Strategic Housing Development Large Scale Residential Development at Hartfield Place, Swords Road, Whitehall, Dublin 9

Response to ABP Opinion and DCC comments on Pre
Application Consultations

Eastwise Construction Swords Limited.

March 2022

DESIGN INTENT DRAWING

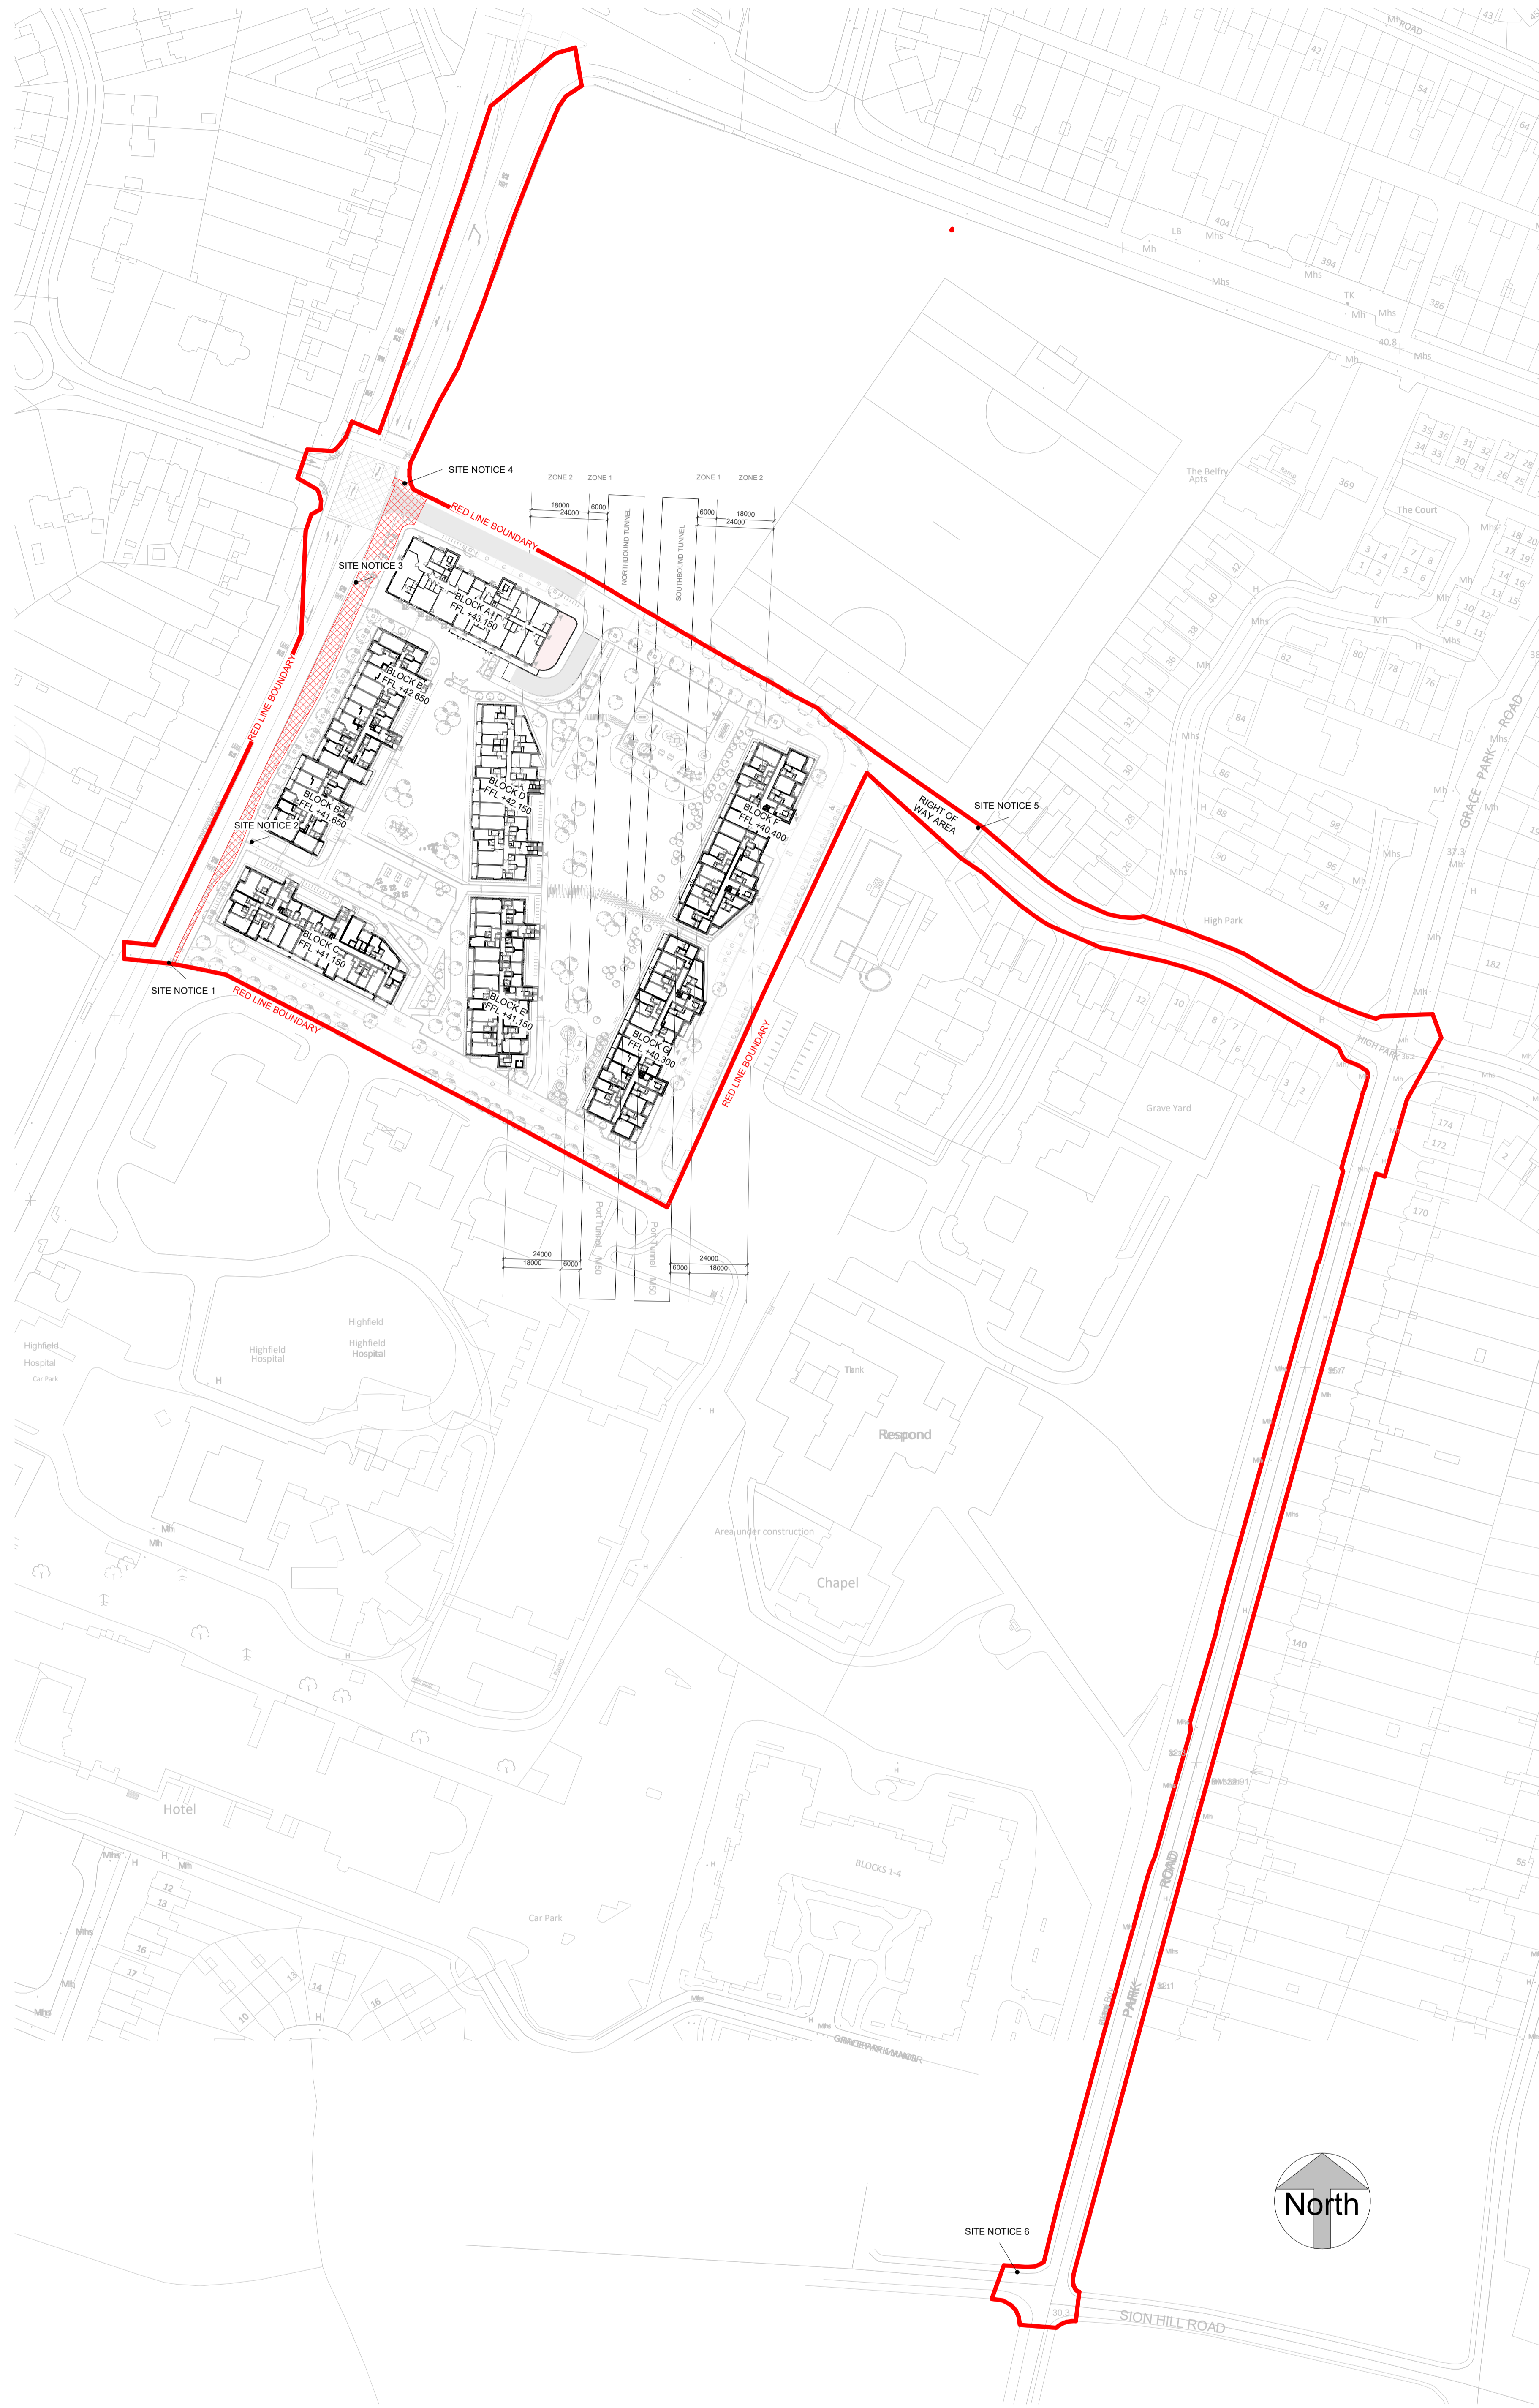
The applicant is requested to outline any lands for Taking in Charge by Dublin City Council.

The Taken in Charge lands are shown in AECOM Drawing PR379360-ACM-XX-XX-DR-CE-20-0003 and below in Figure 2.11
